OAKLANDS FARM SOLAR PARK

The Applicant's Comments on Responses by Interested Parties to the Third Written Questions and other Submissions made at Deadline 6 December 2024

Document Ref: EN010122/D7/15.4

Figure 1a: Habitat constraints plan

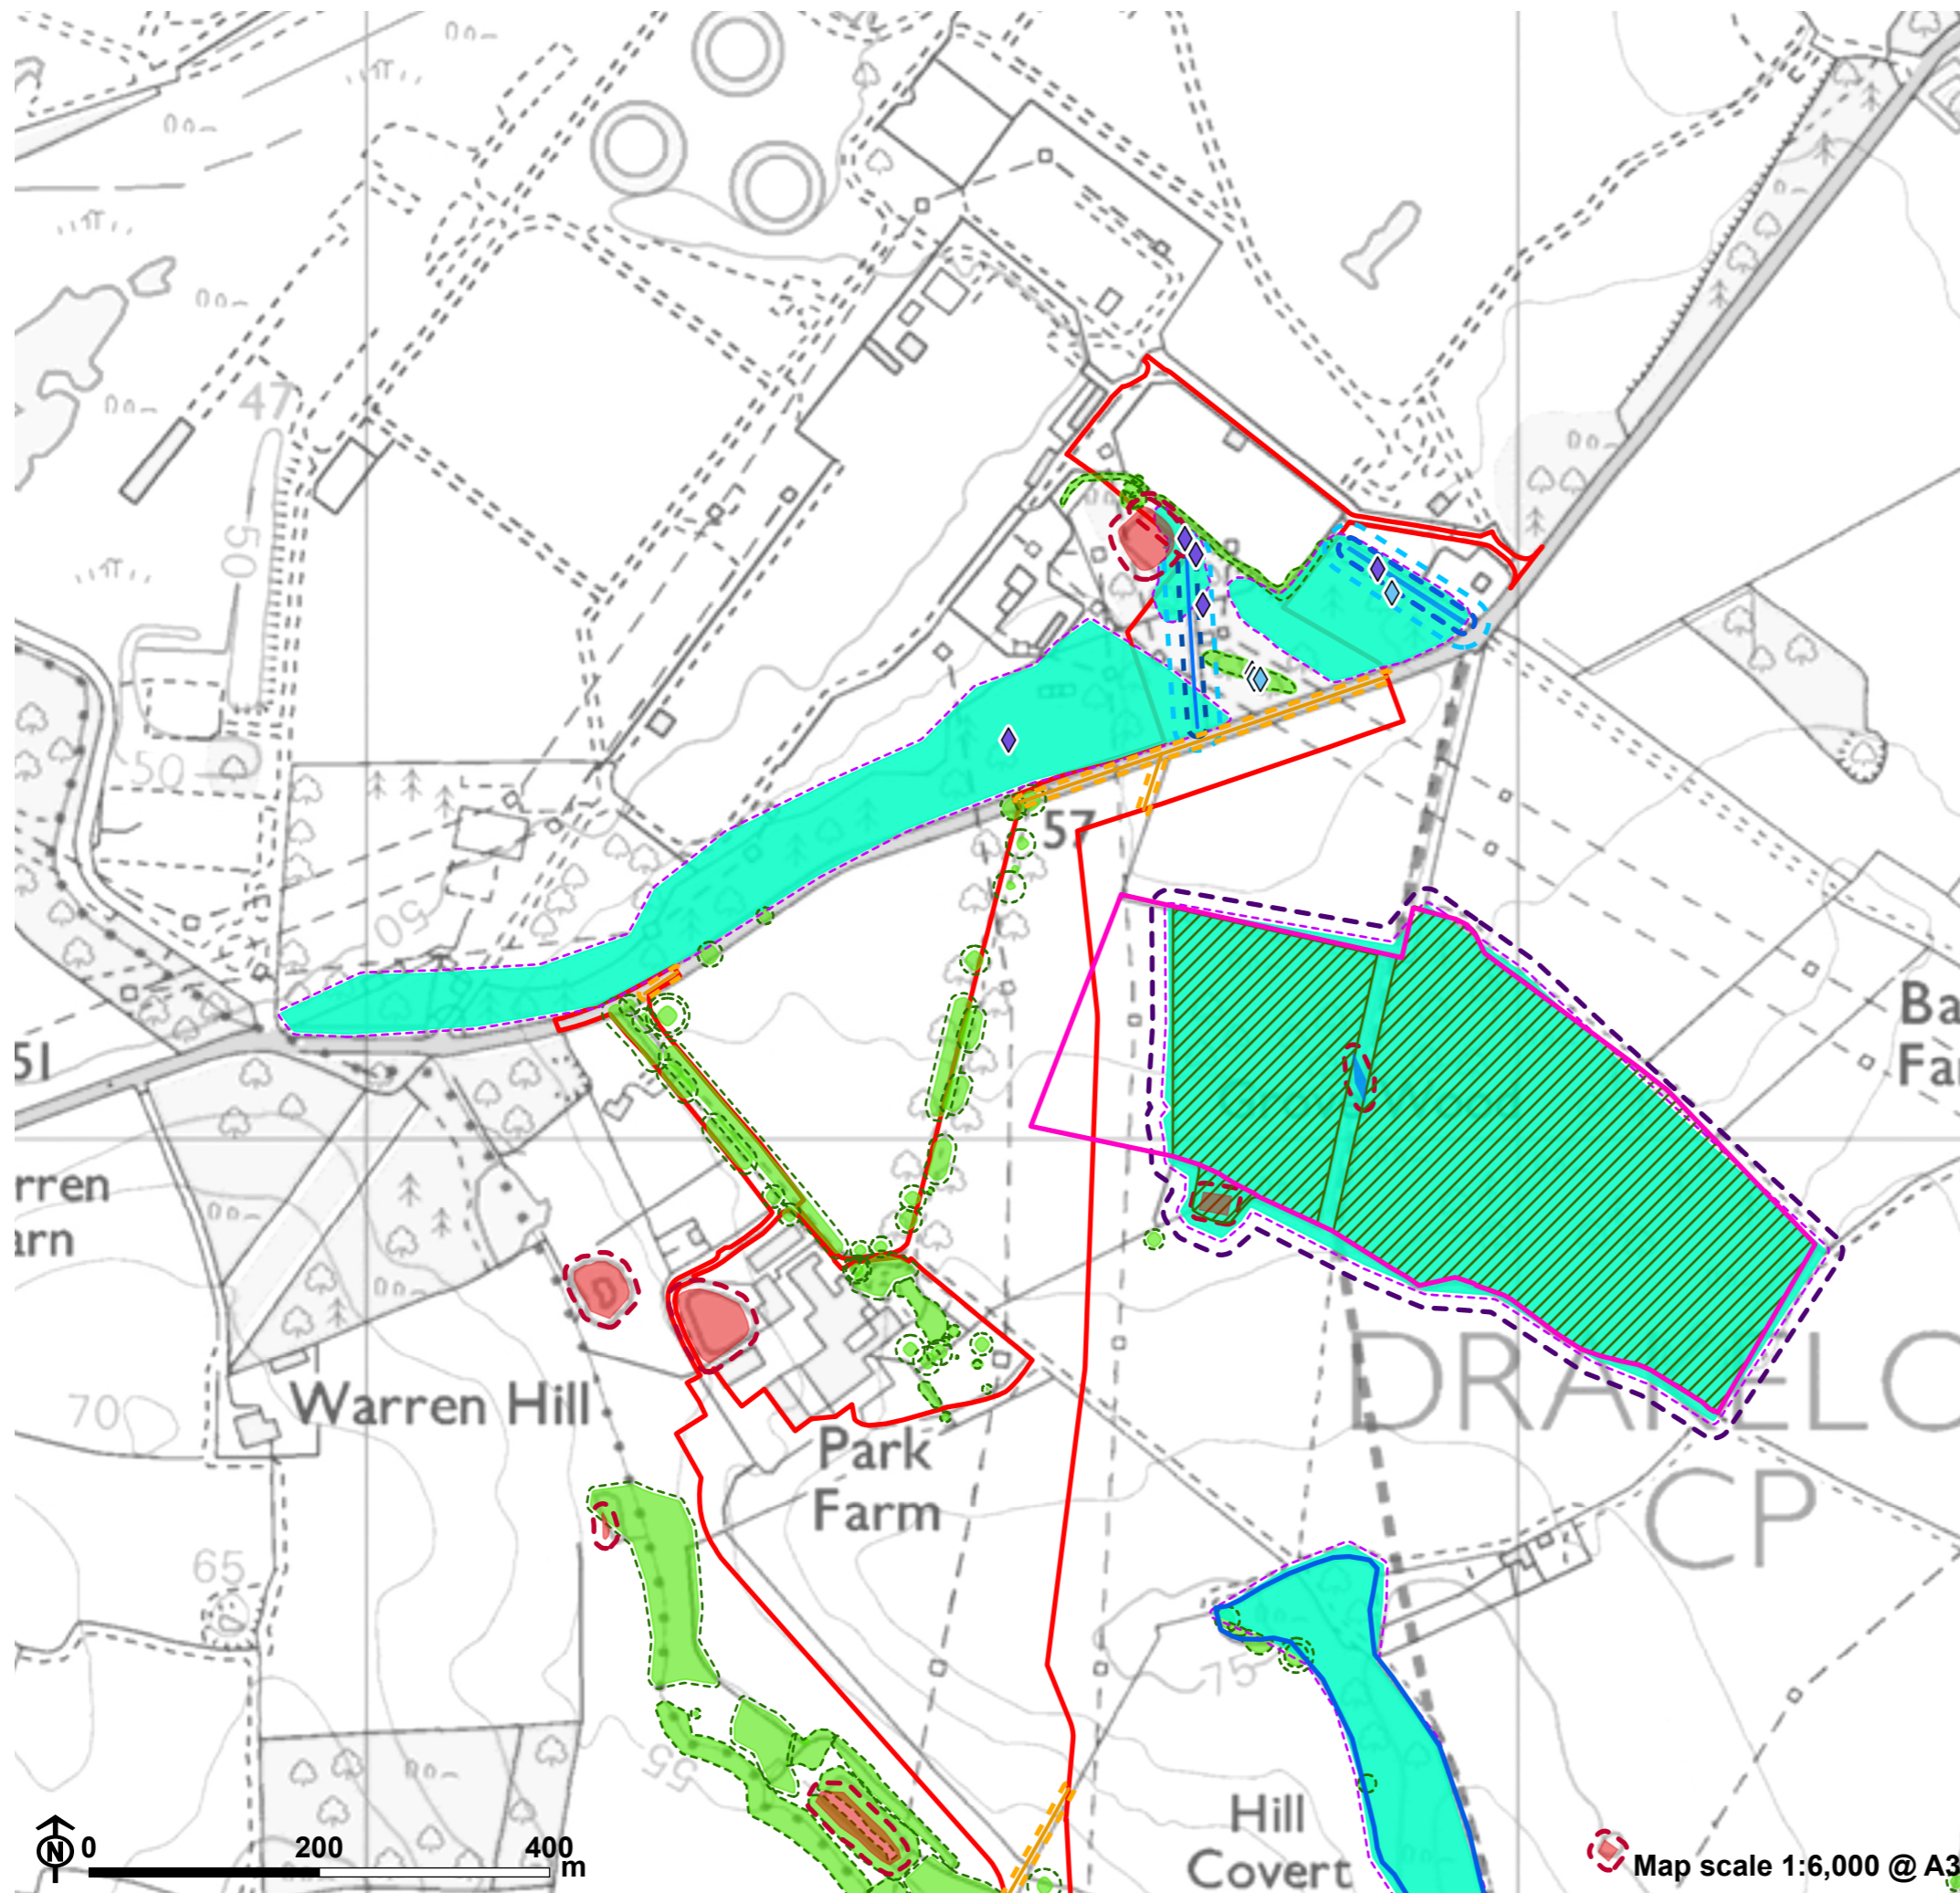
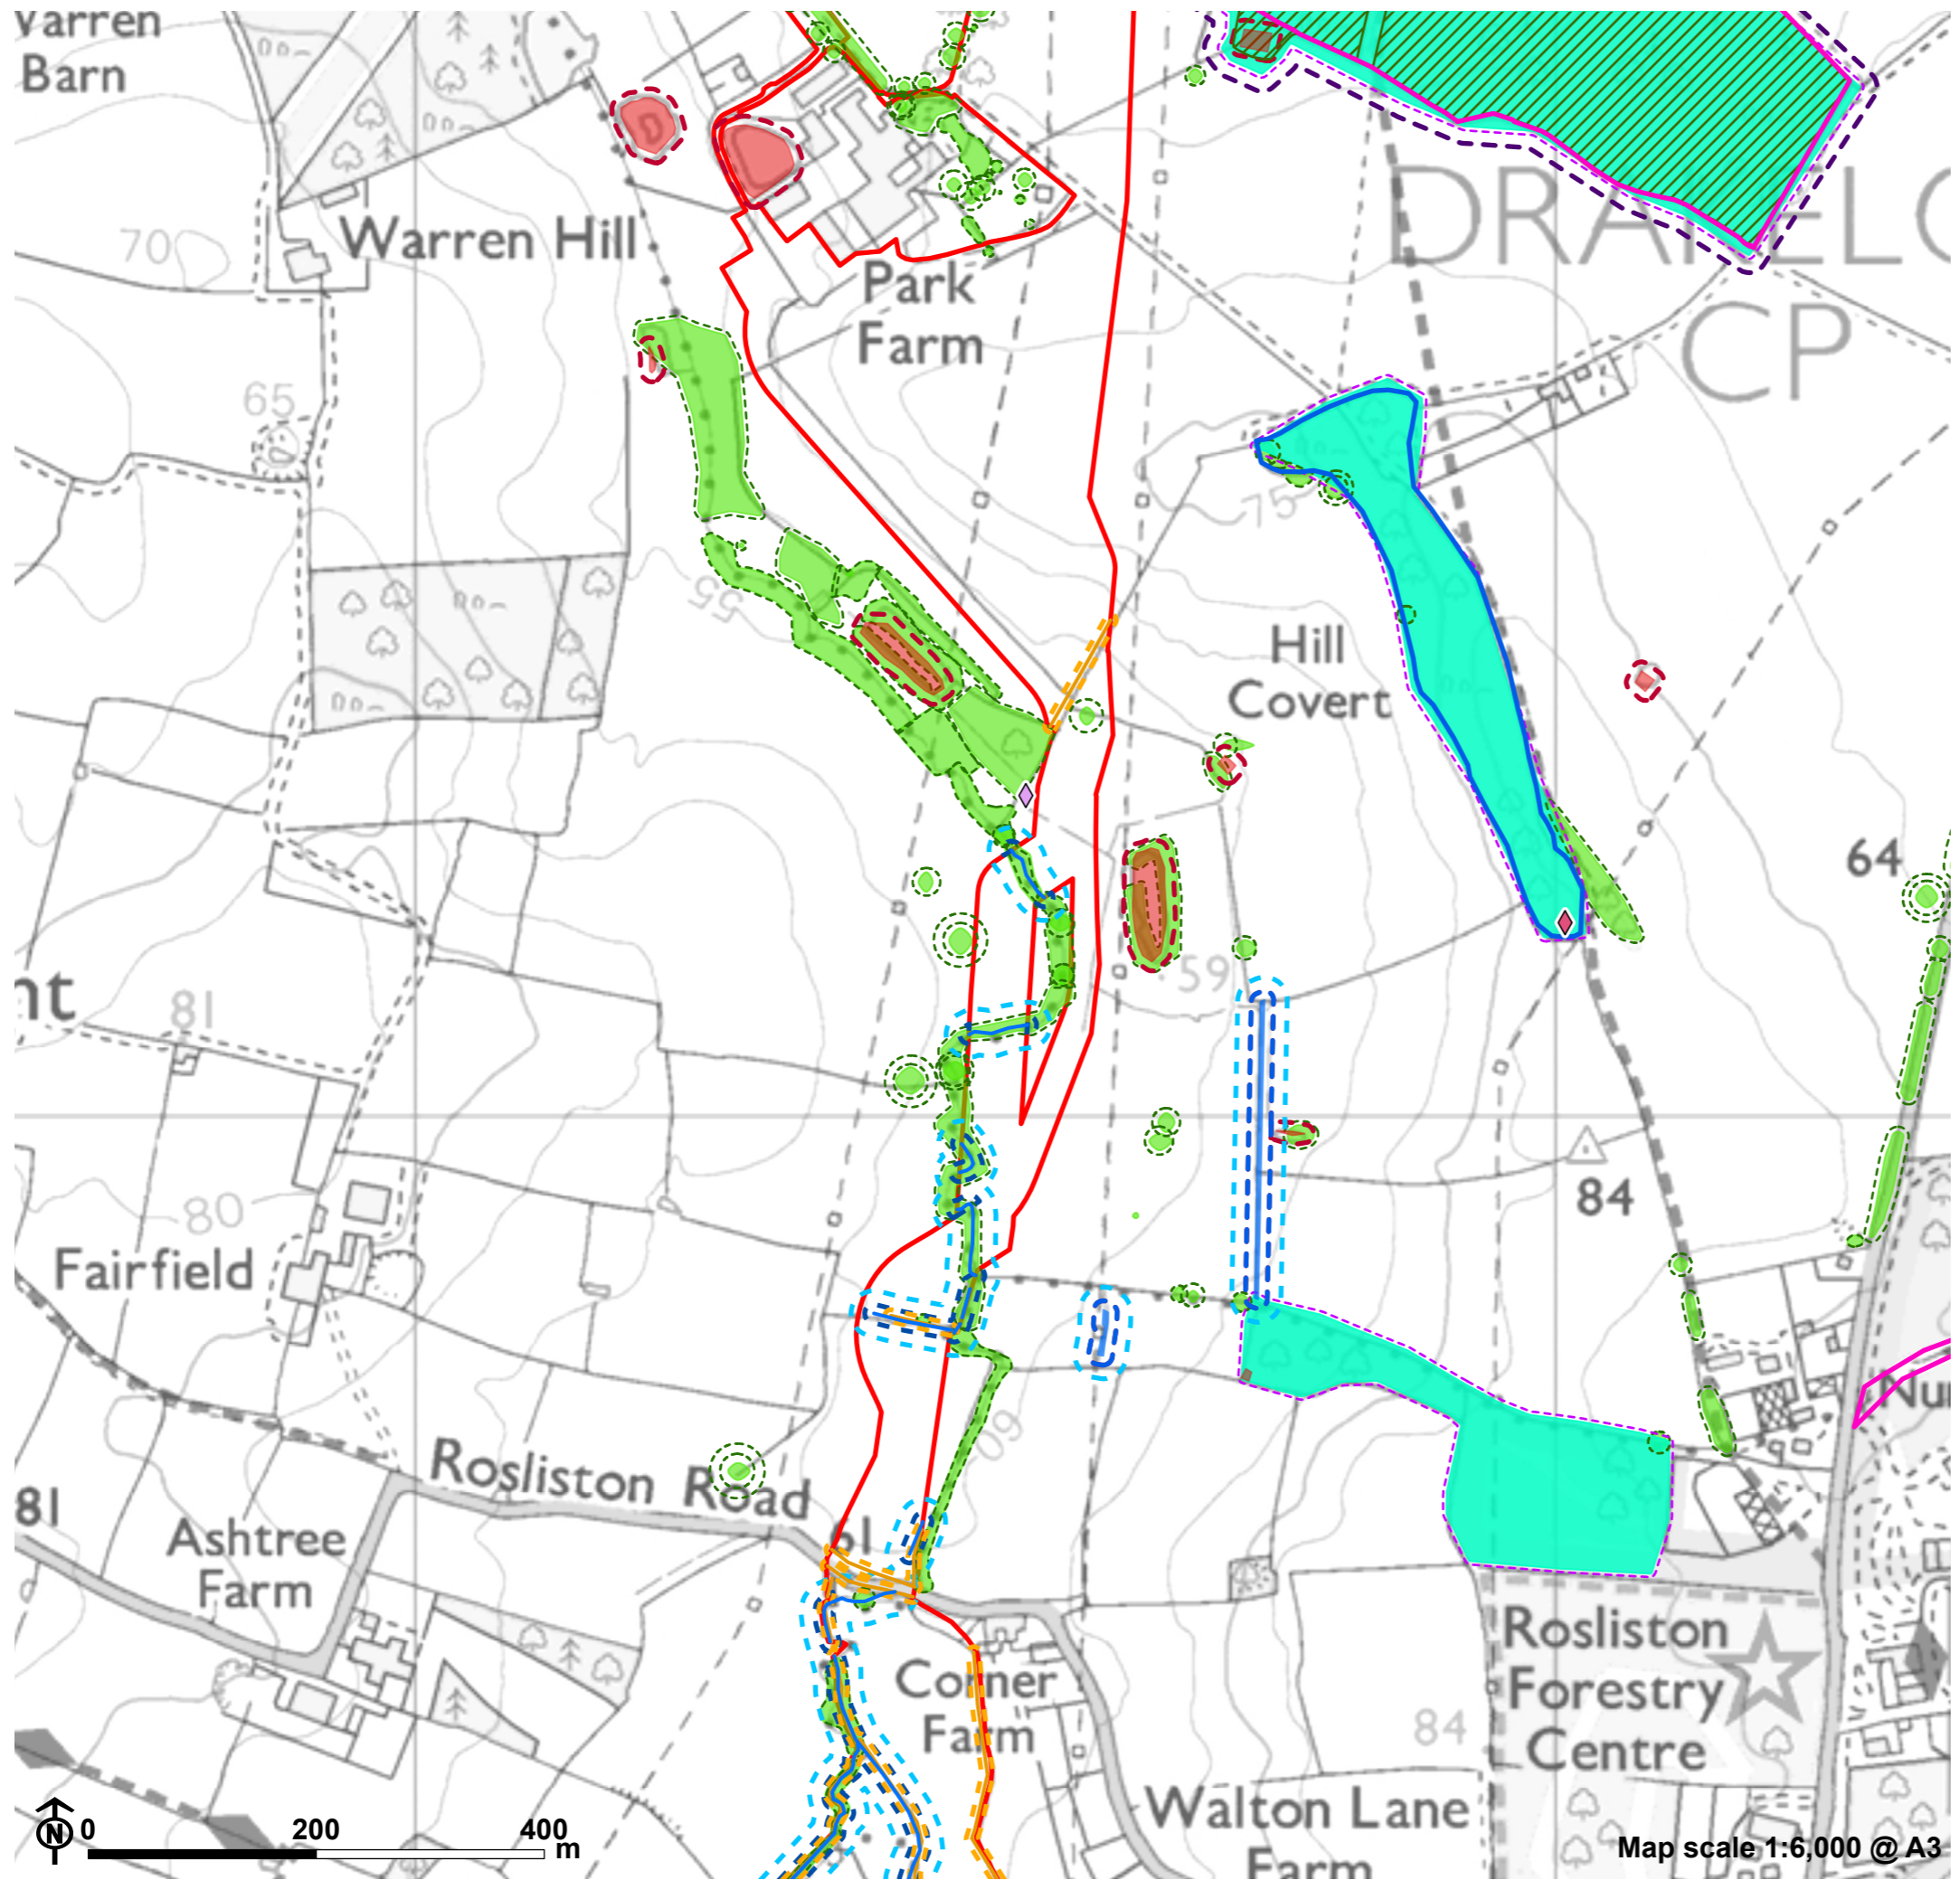
7.3	Applicant, SDDC, DCC			
	<p>Habitat Constraints Plan</p> <p>SDDC [REP4-014] and DCC [REP4-012] referred to the need for a Habitat Constraints Plan with interpretable maps to provide the necessary details and extent of site clearance works relating to buffer zones to sensitive features such as ancient/ veteran trees, other retained trees, ponds, watercourses, hedgerows and woodlands.</p> <p>The Outline CEMP [REP5-011] includes provisions for a Habitats Constraint Plan [Section 2.8.5] and buffers [Sections 2.6.4, 2.6.5, 2.8.2, 2.8.3, 2.8.5, and 2.8.6]. The Applicant provides a series of interpretable maps of habitat constraints [REP5-030].</p> <p>a) Please could the Applicant add the draft interpretable maps to the Outline CEMP [REP5-011] and secure that interpretable maps be included in the final CEMP?</p> <p>b) Please could SDDC and DCC comment?</p> <p>c) Please could SDDC and DCC also summarise any outstanding concerns at Deadlines 7 and 8 with suggestions about how they might be addressed?</p>

Applicant at D6	SDDC at D6	DCC at D6	Applicant at D7
	<p>a) The draft Habitat Constraints Plans have been added to the Outline CEMP at Appendix 4. A final version of the Habitat Constraints Plans will be delivered as part of the final CEMP as secured by Requirement 9(2)(n).</p> <p>b) No response required.</p> <p>c) No response required.</p>	<p>b) SDDC have reviewed those interpretable maps and they provide useful clarity and should be attached to the Outline CEMP for further comprehensive review.</p>	<p>DCC welcomes the inclusion of the habitats constraints plans referenced in the OCMP at 2.8.5 including buffer zones, and requirement 9 for approval of the LPA prior to construction.</p>	<p>The Applicant welcomes the comments from both SDDC and DCC confirming acceptance of the draft Habitat Constraints Plans. No further action is required.</p>
